Application for a non-material amendment following a grant of planning permission.

Single storey wrap around extension under flat roof and loft conversion with side dormer

Reference number: EP/129/18/HH

Lowering of garage roof and amended to material treatment on rear gable from brick to tile hanging

REAR ELEVATION  
EAST  
PROPOSED ELEVATIONS  
1:100

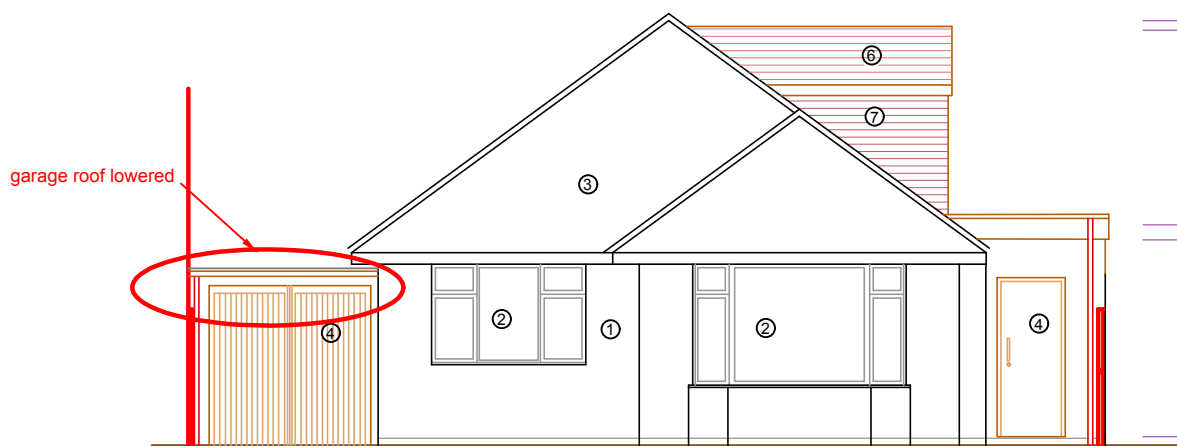
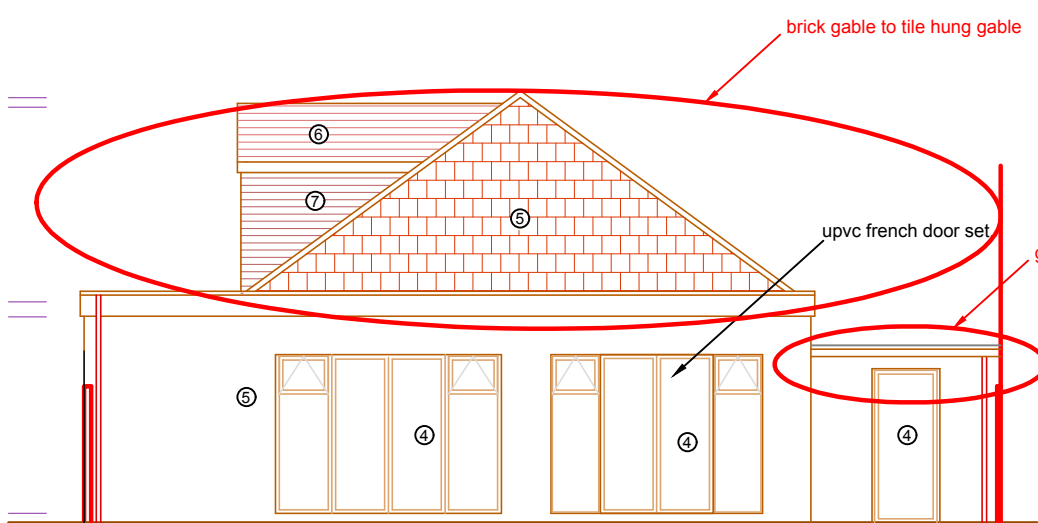
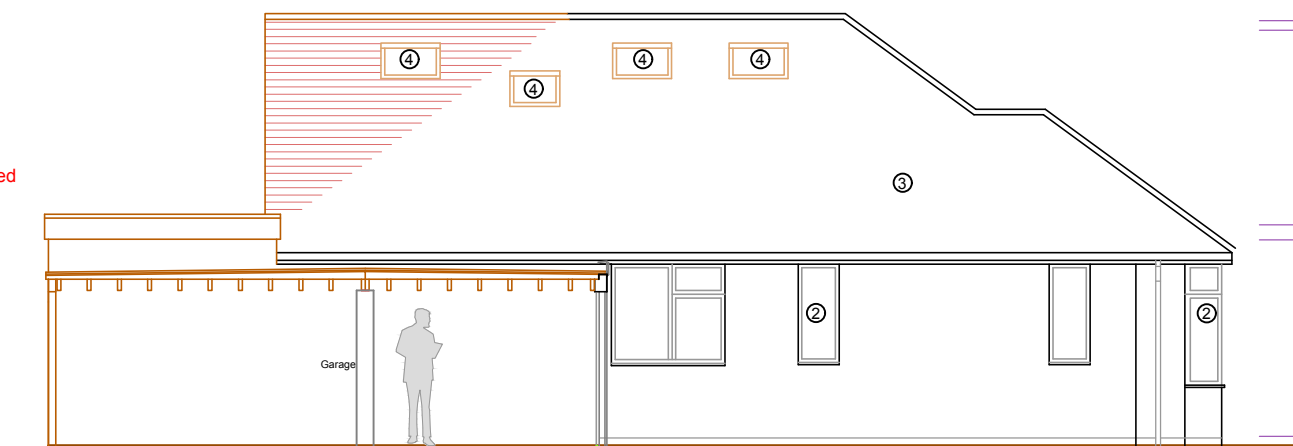
Lowering of garage roof - to simplify construction against neighbouring property
Rear gable - to simplify construction
